30<sup>th</sup> November 2022

**RE: PLANNING APPLICATION REF: 3/2022/1022- Land At Morans Farm, Pendleton Road, Wiswell, BB7 9BZ**

Drawing:
site layout & landscaping

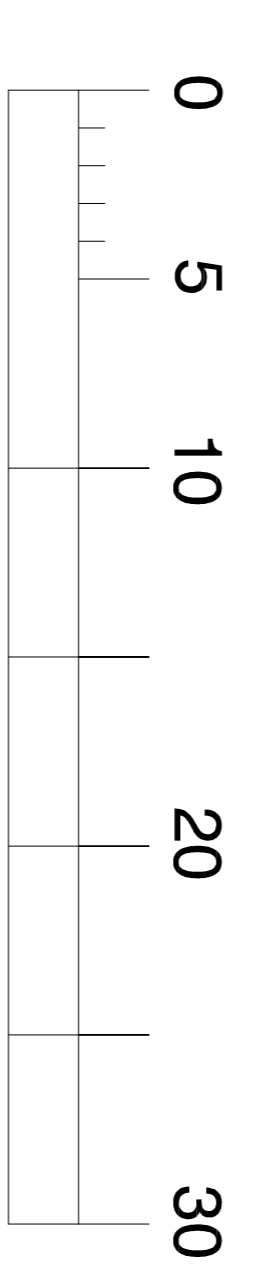
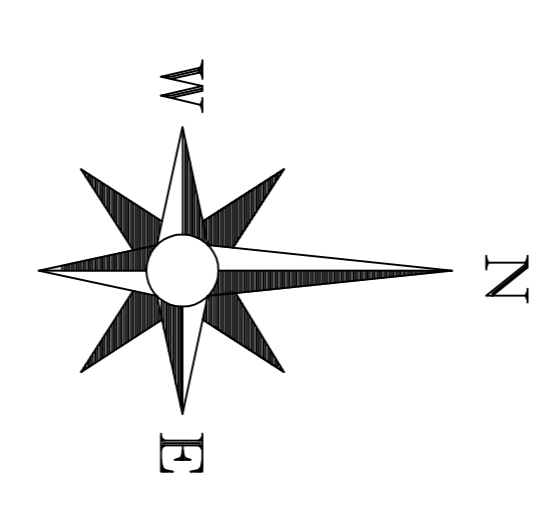
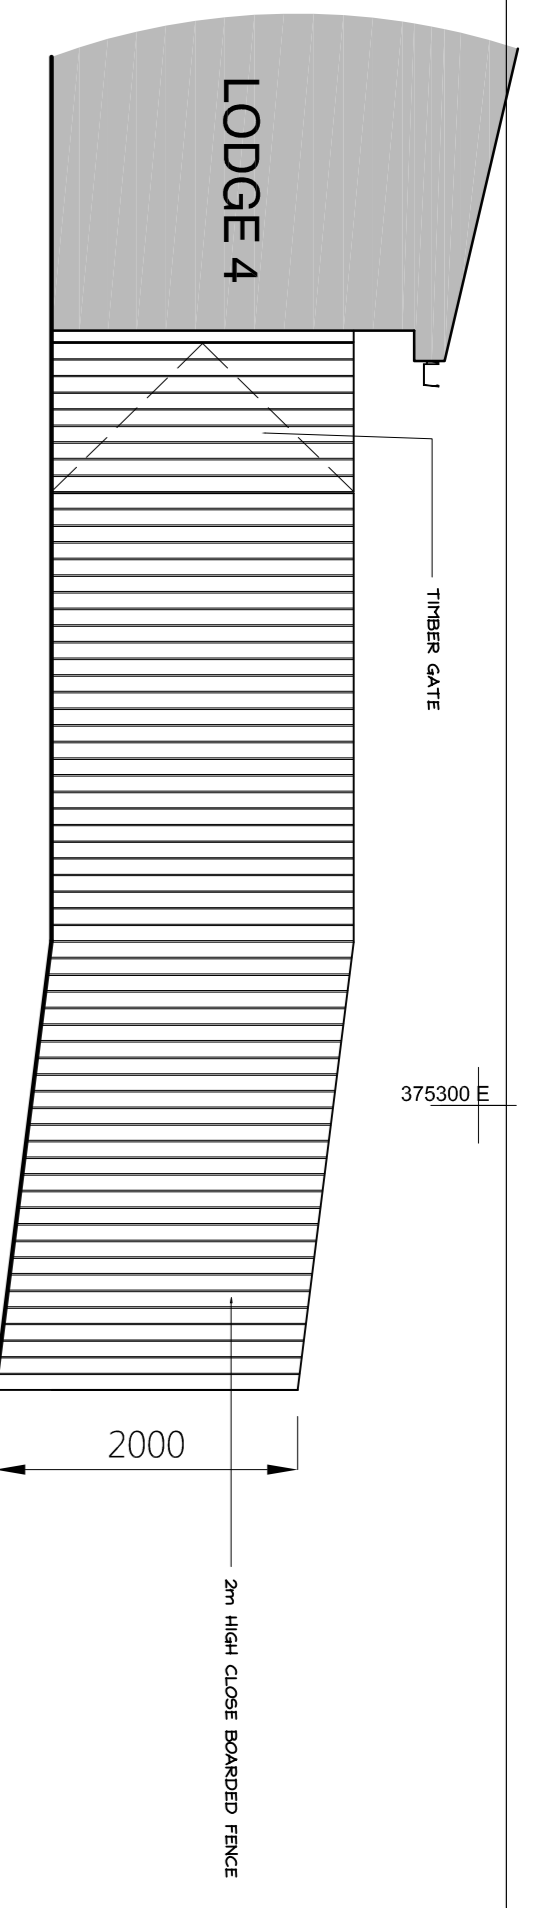
The decking area associated with lodge [REDACTED] extends further than is indicated on the drawings submitted on the variation of conditions application past the boundary wall which will allow the occupiers of the lodge when utilising the external decking and hot tub areas to [REDACTED]

There's been additional decking that has been added and it's so massive it [REDACTED] (which is a lot more than the variation order states). This allows [REDACTED]
